Wylfa Newydd Project

Horizon's Responses to the eNGOs Post January Hearing Submission Documents

PINS Reference Number: EN010007

12 February 2019

Figure 13. Difference in H_s for the fully-built (with cofferdam) 2023 scenario minus baseline, Winter 99th % wave from the NW (300°) (from Jacobs 2018)

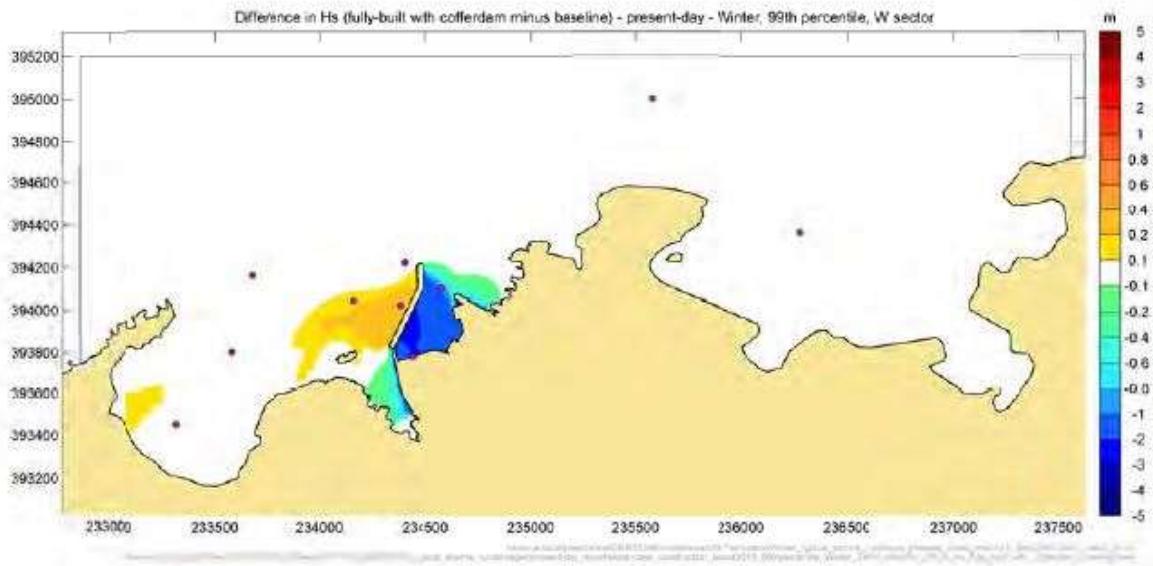
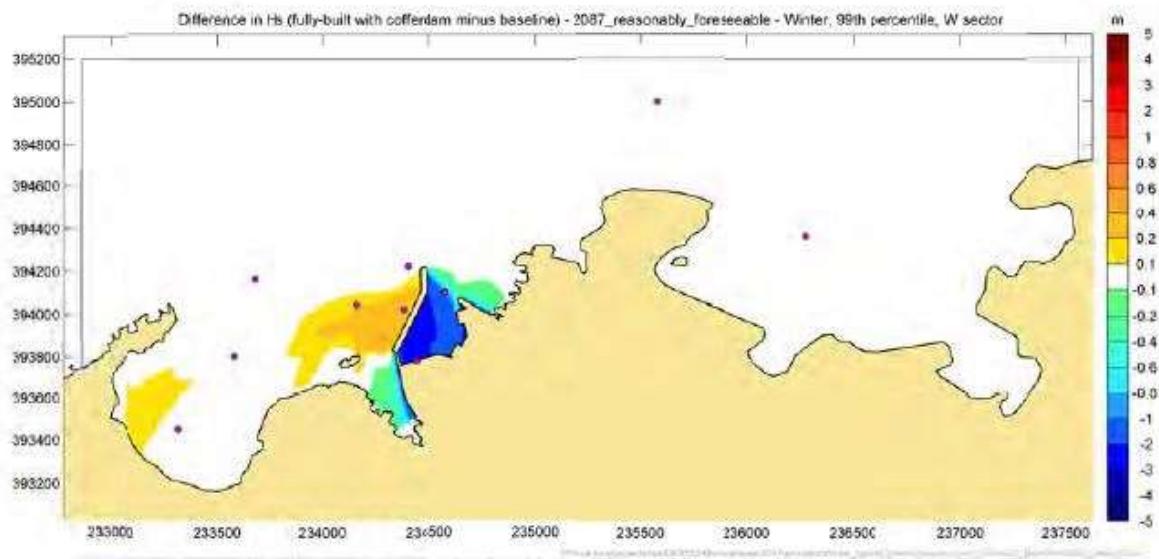
- 2.2.8 The key issue raised by the NT is that of the potential for wave reflection off the western breakwater and the consequent possible alterations to the inshore wave climate, and the ensuing consequences for overtopping and sediment transport along Esgair Gemlyn.

- 2.2.11 A fraction of incident wave energy from these directions, for the worst case, is observed in the modelling studies to be reflected off the western breakwater. The model was run with a reflection coefficient of 0.45, assessed to be a suitable value for the design of the breakwater, meaning that only 45% of the incident wave energy is reflected. For the worst case situation, NW and W storms (incident Hs 4.03m 286°; Hs 3.5m 246°; respectively), the model finds increases in wave heights to the immediate west of the breakwater of 0.2 – 0.4m (these amplified sea states do not, however, extend farther west than the Cerrig Brith headland), and small (0.1 - 0.2 m) increases in wave height in the southwestern corner of inner Cemlyn Bay. It is important to note in this context that detailed analysis of the model predictions versus the S9 wave buoy located just outside Cemlyn Bay shows that the model, on average, slightly overpredicts the waves compared with the measurements.

- 2.2.13 For incident waves from the NW, the area over which enhanced wave heights (and what might be expected to be slightly amplified shear stress) is found, at its largest (ca. 50 x 50 m) in the alongshore and offshore direction, appears to be coincident with the area of coarser bed sediments in the vicinity of the ebb tidal delta and does not appear to be shore connected. For waves derived from the more westerly regions, the area affected is larger, perhaps covering some ca 200m x 400m of the Bay in the alongshore and offshore direction respectively, and is shore connected. Critically, however, it is connected only at the western end of the shingle ridge; the greater length of the ridge is unaffected. This limited spatial extent indicates that the process of reflection

- 2.2.14 The modelling provided in support of the DCO application reveals further that amplification is most pronounced during offshore incident waves over a relatively specific and narrow range (221-271°) and that the proportion of time when the offshore conditions which give rise to increases in inshore wave height of the order of 0.1-0.2 m is only 4.9%.

- 2.2.15 In summary:
- the proportion of time that the offshore conditions occur when reflection could be a potential issue is low (<5%) and is limited to a restricted wave approach direction (W-NW);

- the breakwater acts to dissipate a significant fraction (over half) of the incident wave energy that could be reflected;
 - significant wave reflection occurs only during already energetic periods, adding only minor additional hydrodynamic/wave energy to the inshore system;

- the changes in inshore wave height and associated shear stress are small (0.1-0.2 m) under a worst-case condition; and
 - the areas over which wave height/shear stress is increased are limited (and do not extend over the greater area of the Esgair Gemlyn ridge).
